Mr Clay Preshaw
A/team Leader, Mining Projects
NSW Department of Planning and Infrastructure
GPO Box 39
SYDNEY NSW 2001

Re: Wallarah 2 Coal Project SSD 4974.

Dr Peter Lewis
Director Public Health

Figure 3-1: The severity and frequency of an adverse health impact as a result of ambient air pollution exposure (from WHO [2001])

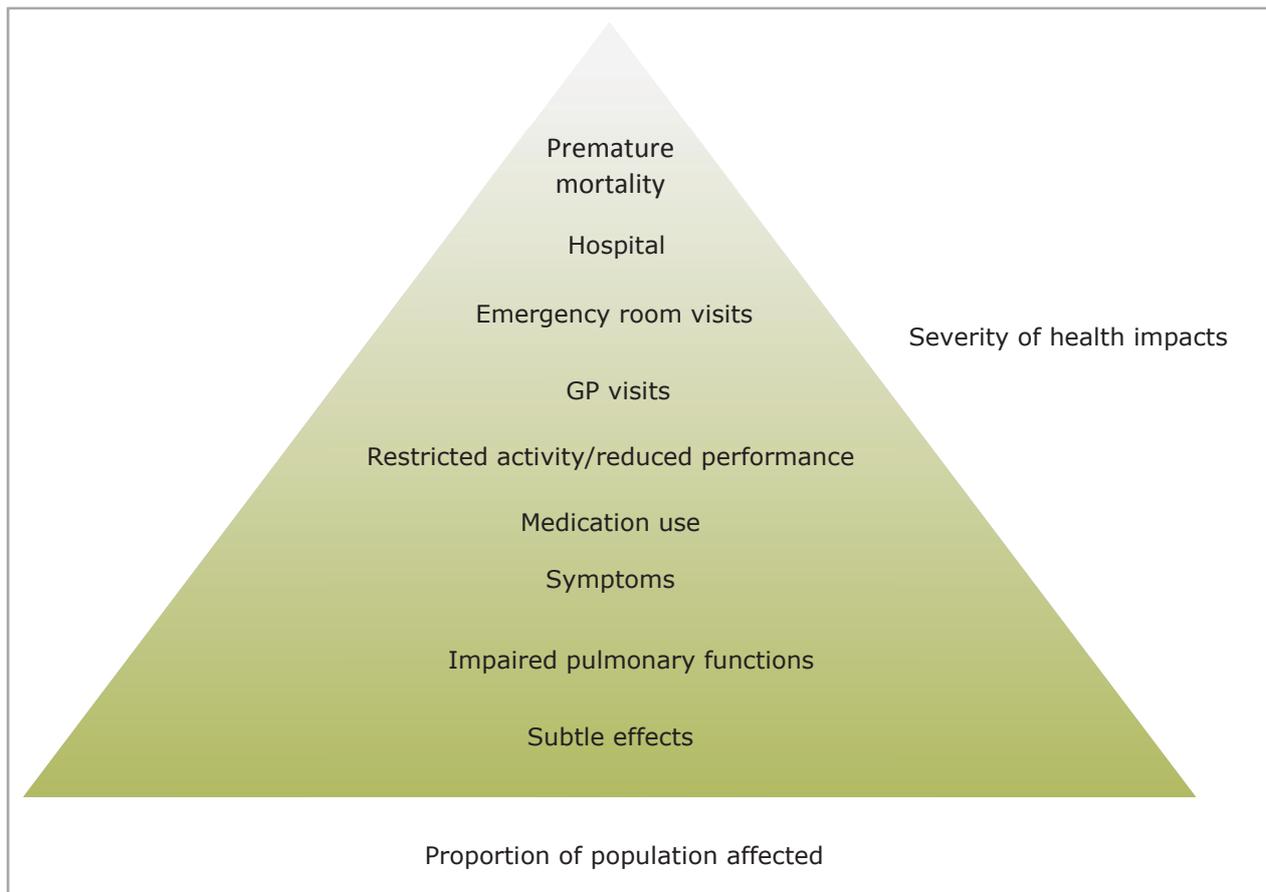
Attention is also drawn to figure 3.1 in Appendix M, where the 'pyramid' of health impacts shows that it is expected there as health events become less serious, they are likely to be more frequent. It is therefore likely that for an exposed population, less severe health outcomes will be more prevalent than deaths and hospitalisations. People exposed to particulate pollution are likely to experience symptoms of airways irritation – cough, runny nose, irritated eyes. Some will develop localised inflammation, for example, sinusitis or bronchitis and may require medical treatment. People with asthma may experience exacerbations due to particulate or other types of air pollution.
